From: Sue Howell
Sent: 11 October 2018 16:05
To: Michael Eastham
Subject: RE: P1456 - Manor Nursery Landscape Plans - Email 1 of 2

Soft Landscape Layout - Infrastructure Planting Manor Nursery, Angmering

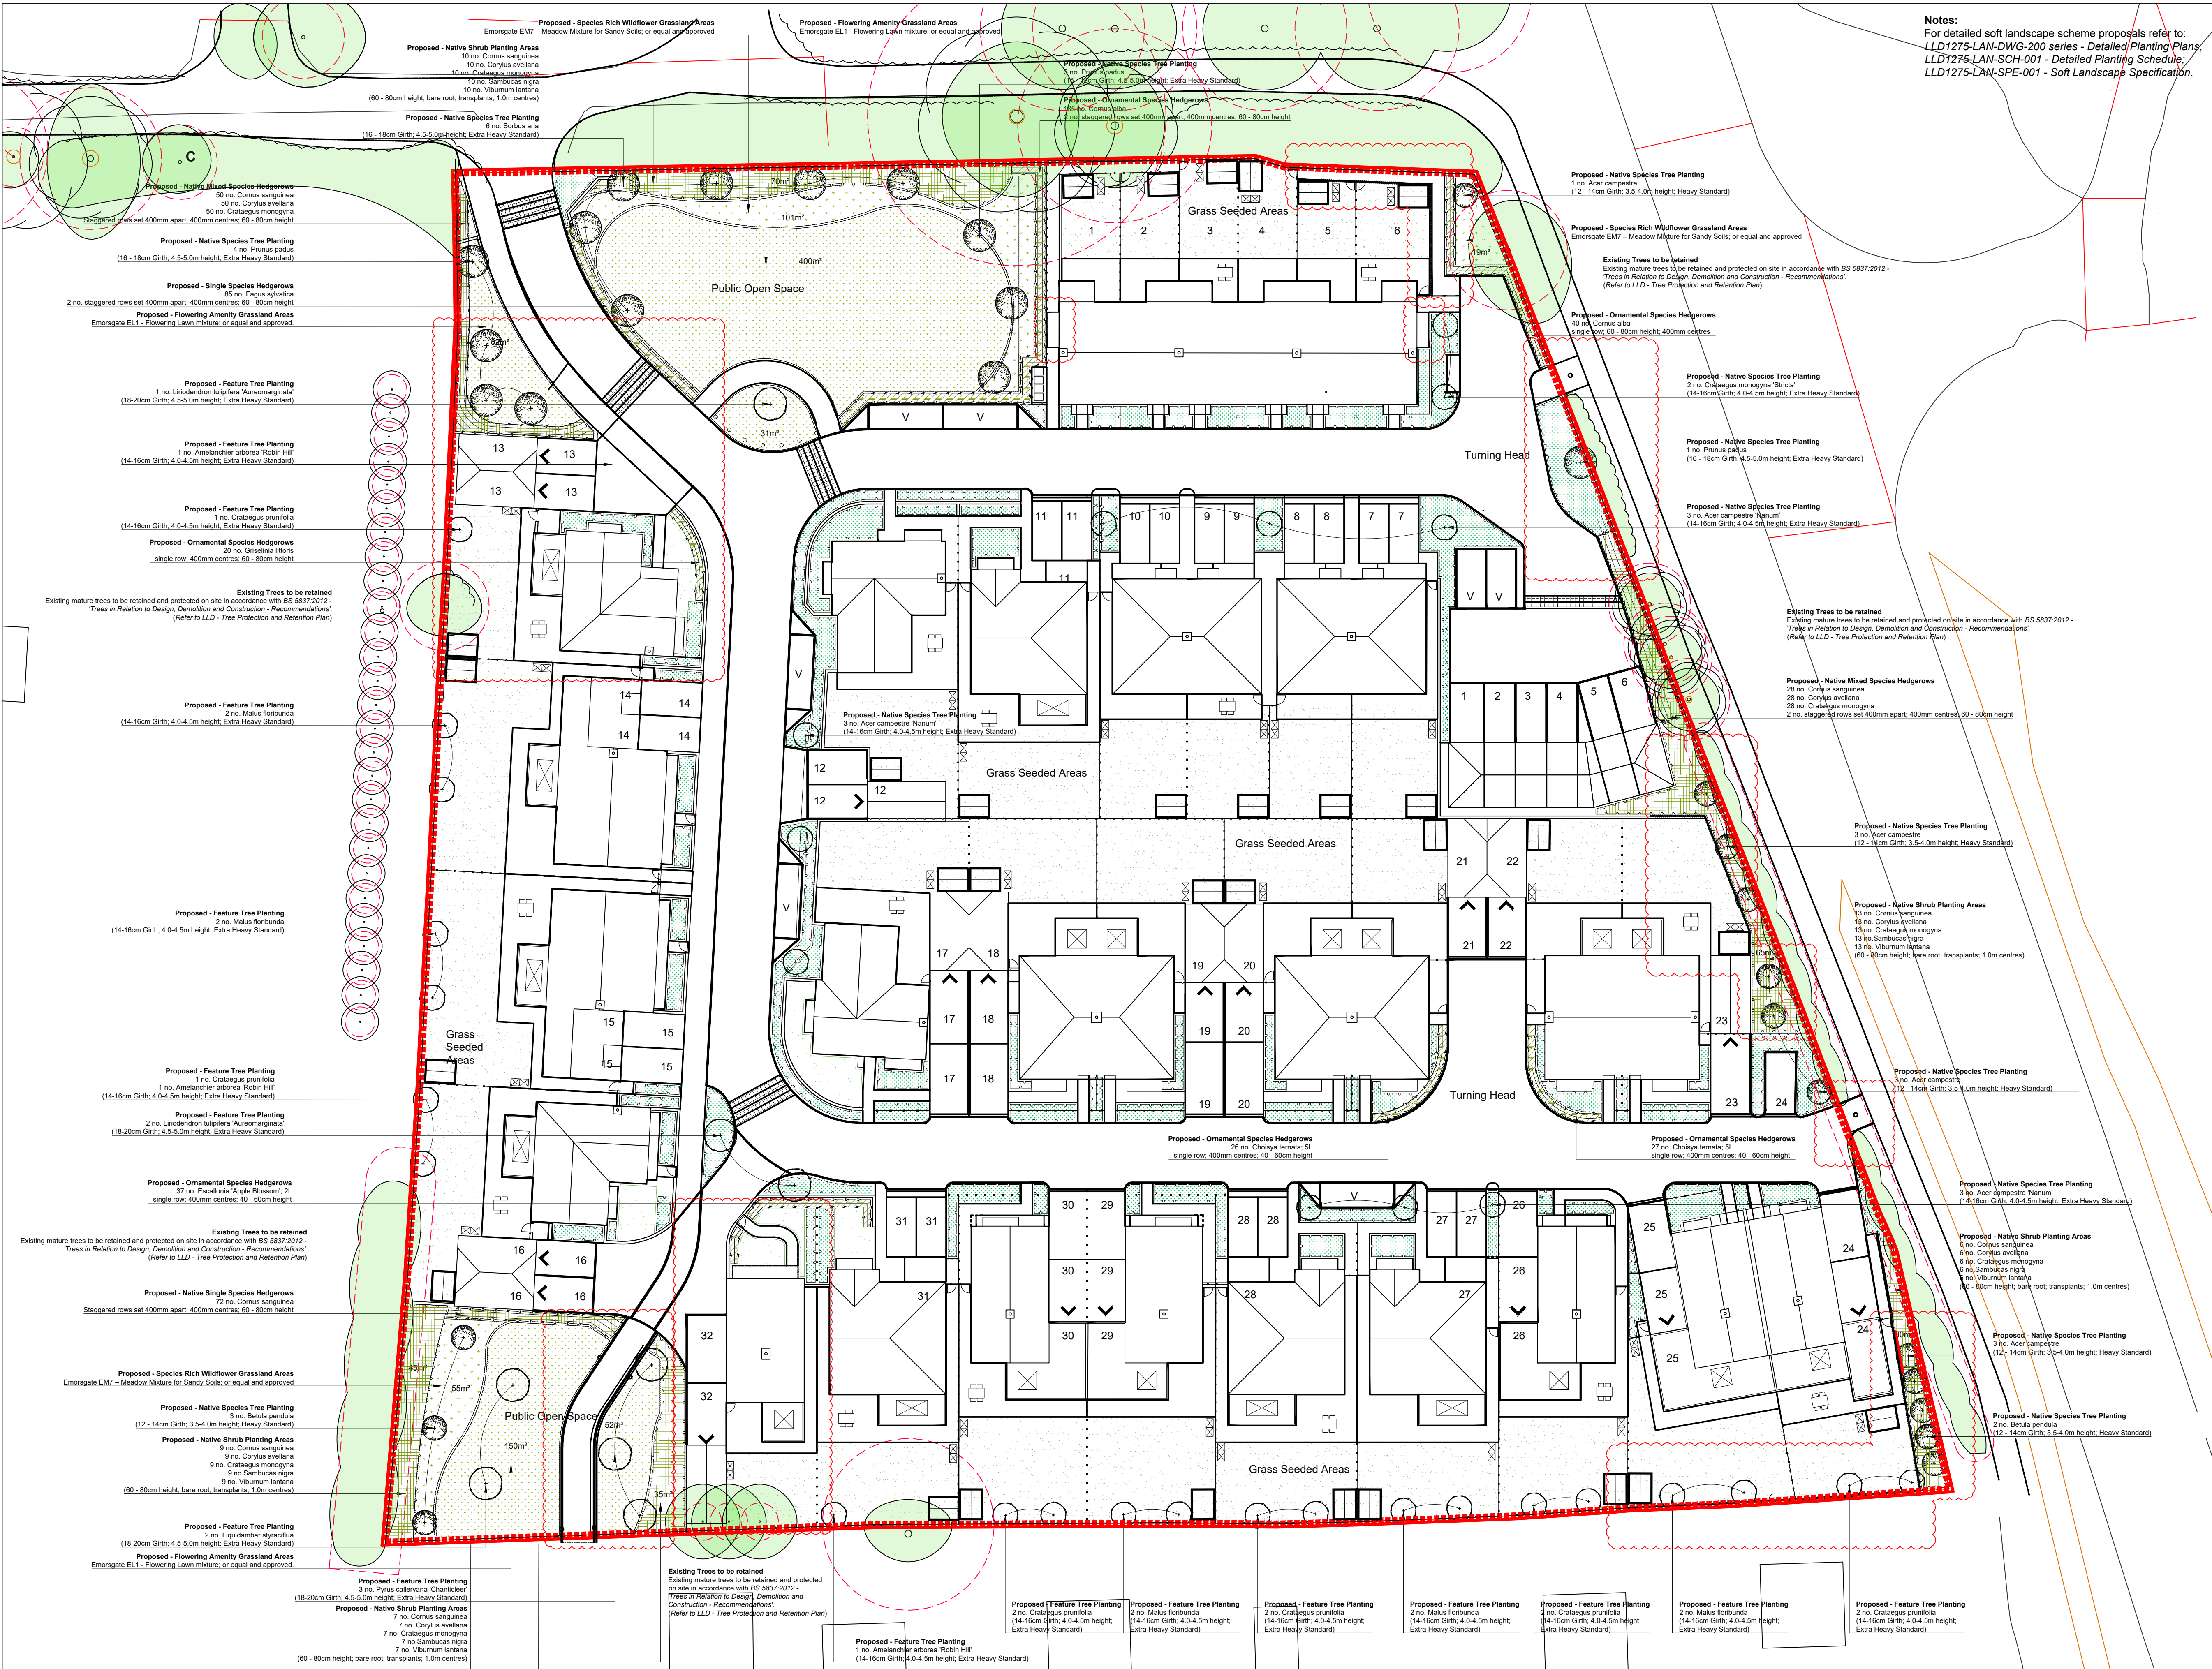
Further to receipt of revised drawings LLD1275-LAN-DWG-200 rev 04 infrastructure planting Dwg detailing the addition of the 13no Extra heavy standard feature trees to the western boundary. I can confirm that the species choice is suitable for location and that these trees proposed at this size will make a valuable addition over time to the screening along this boundary.

I confirm that I raise no landscape objection to the landscape proposals under application A/38/18/OUT with open space and offsite fitness contribution also recently approved.
